DOUBLE SPUR RANCH

Project No. 22001

LETTER OF INTENT

RE: 52130-00-007
12420 N. Meridian Road

DOUBLE SPUR RANCH MINOR SUBDIVISION FINAL PLAT

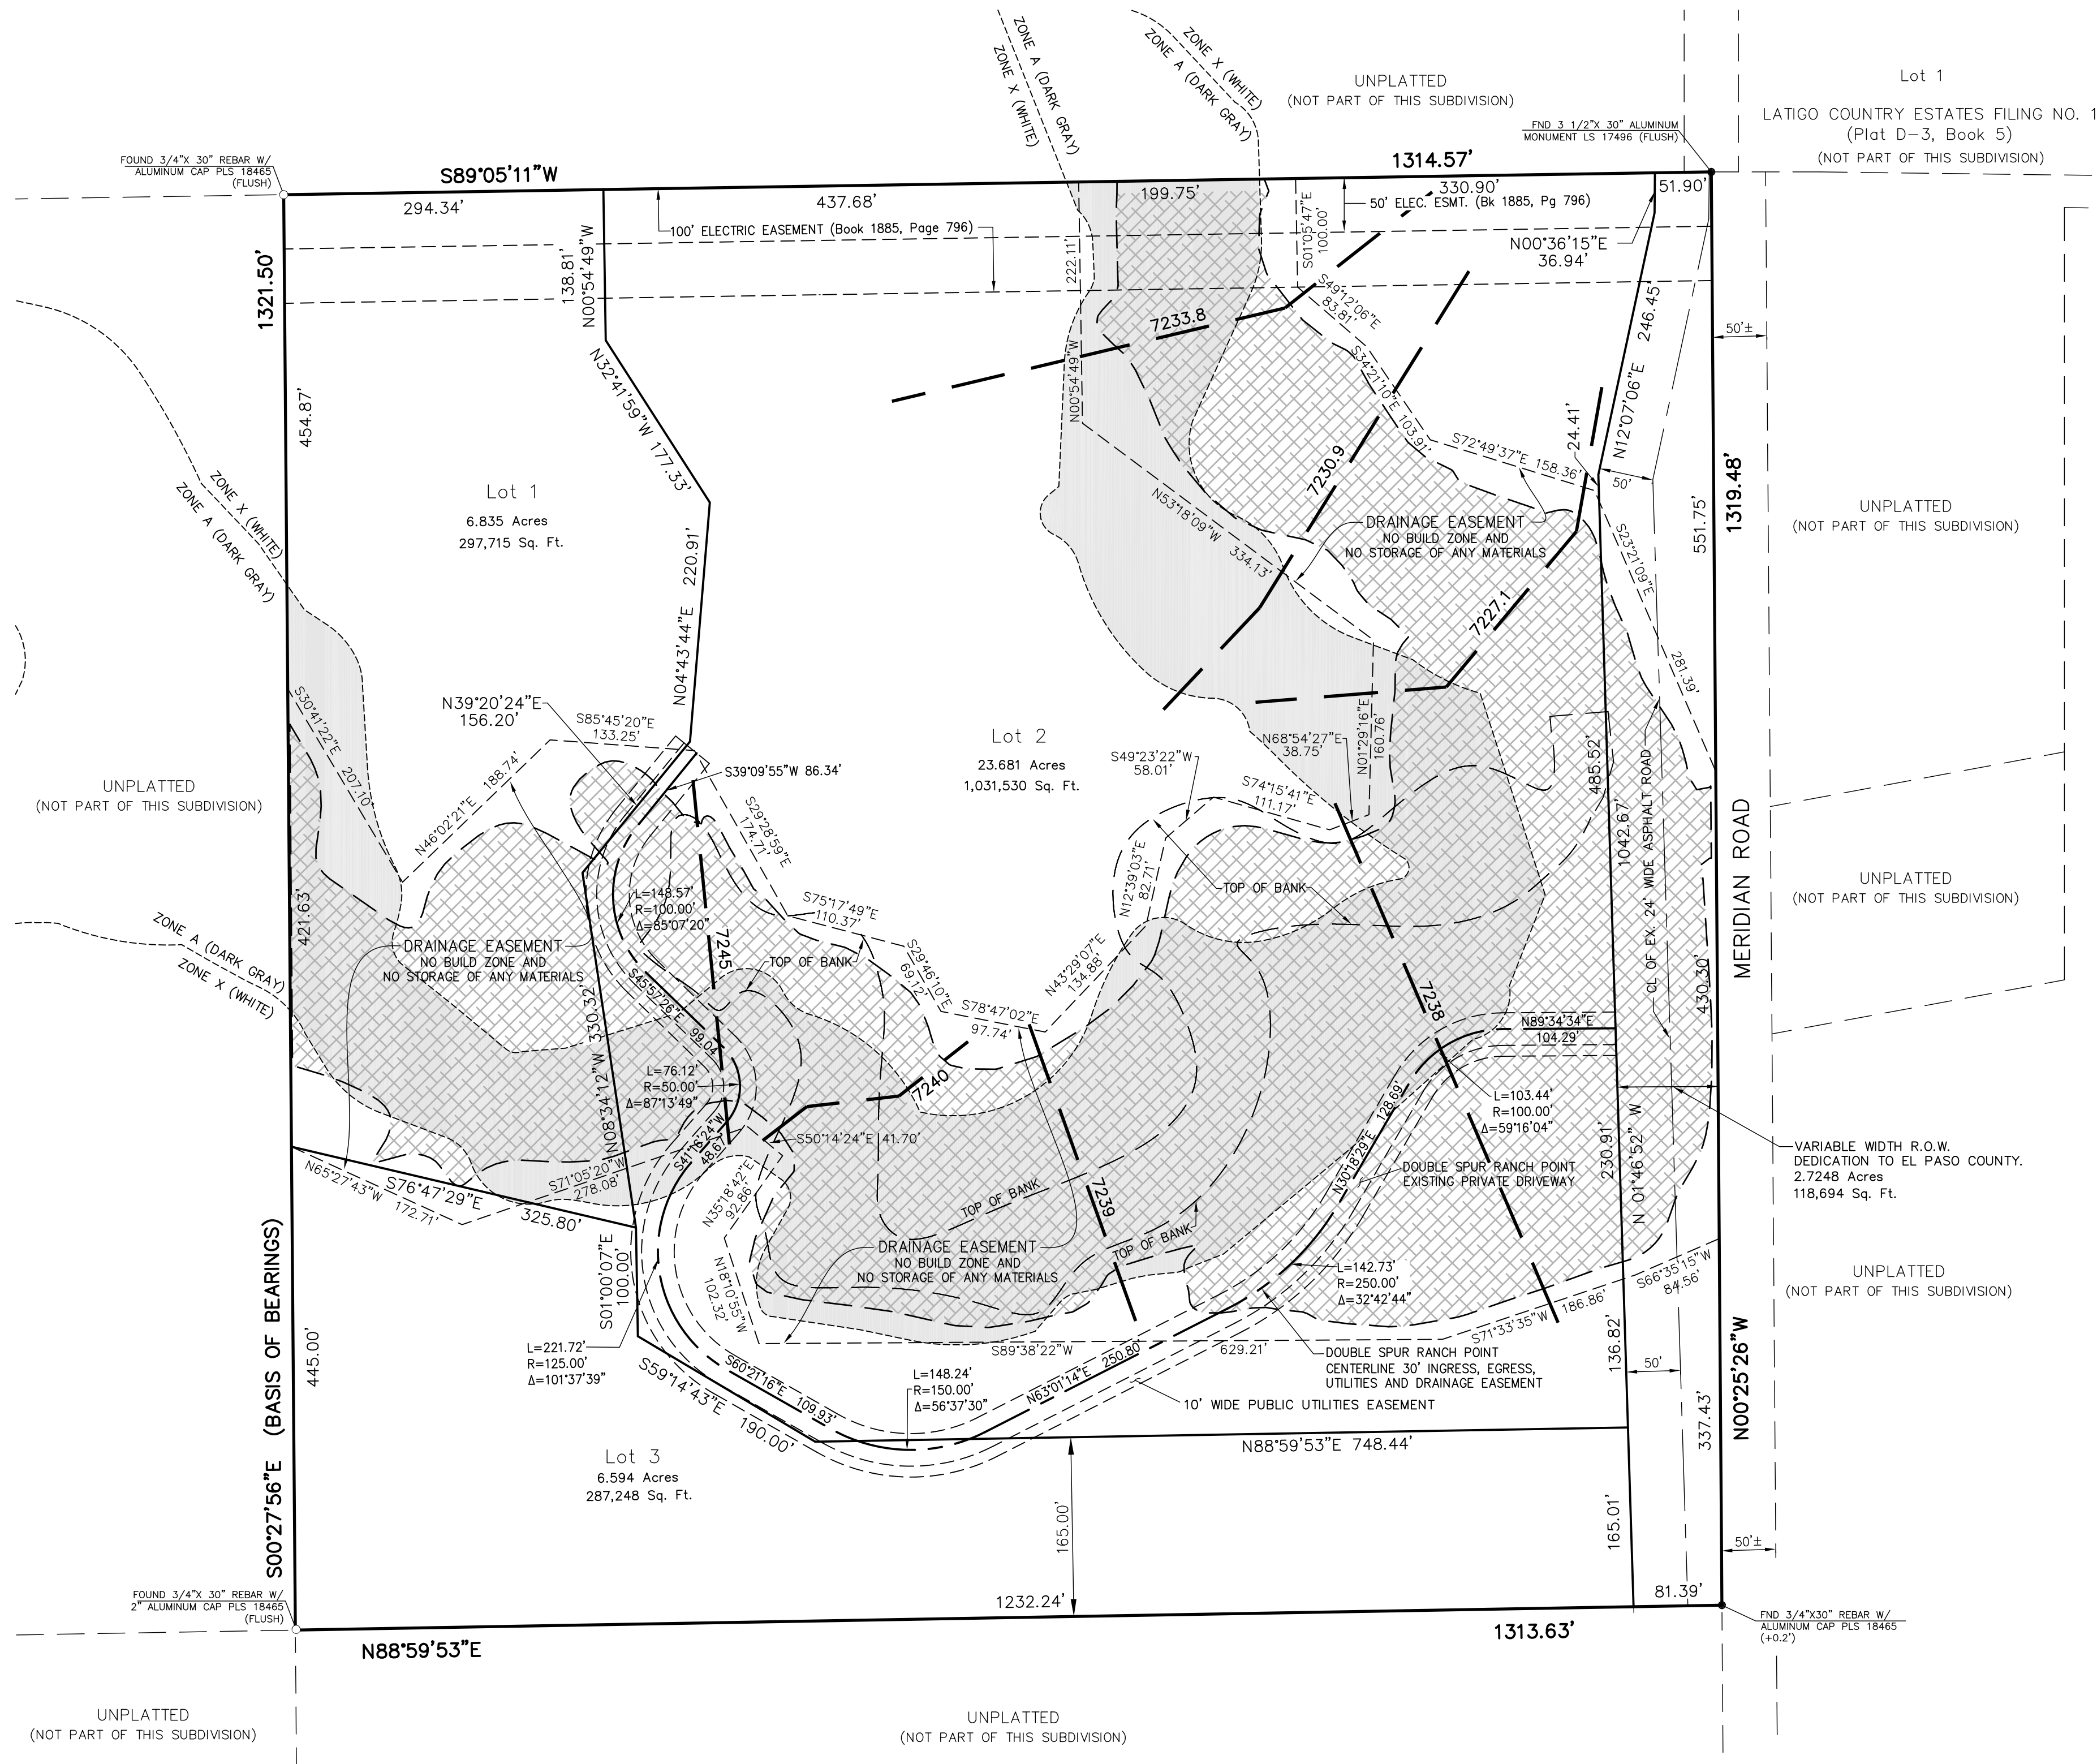
Unresolved V1 comment:
Private driveway or road? please clarify
